Please ask for: Ms Iqraa Malik
Email: iqraa.malik@terraquest.co.uk
Telephone: 0121 234 1390
Our Ref: FG/162/21/HH
Your Ref:
Date: 10th September 2021

Application for Planning Permission for Works or Extension to a Dwelling

Development: Erection of single storey store room to front
Location: 33 Downview Avenue Ferring BN12 6QW

Site Plan 1:200

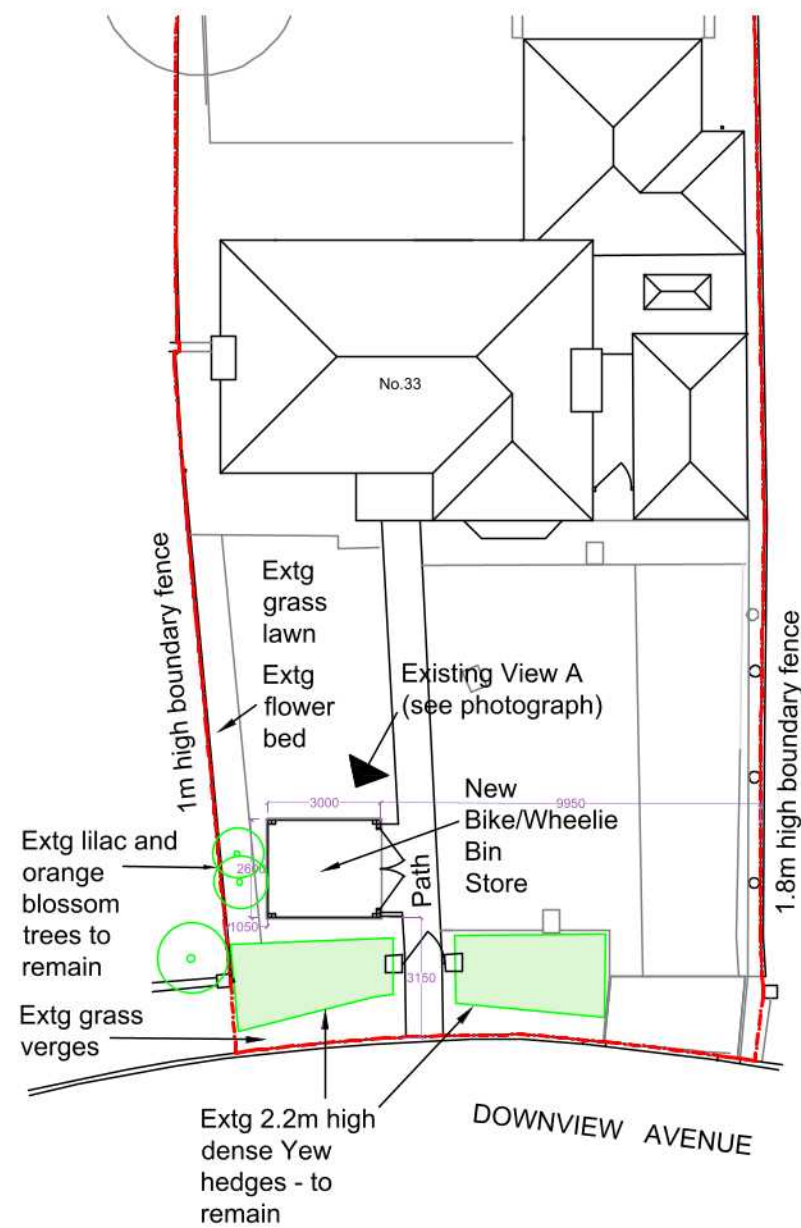
Please provide the dimension from the proposed development to the other side boundary on the block plan.
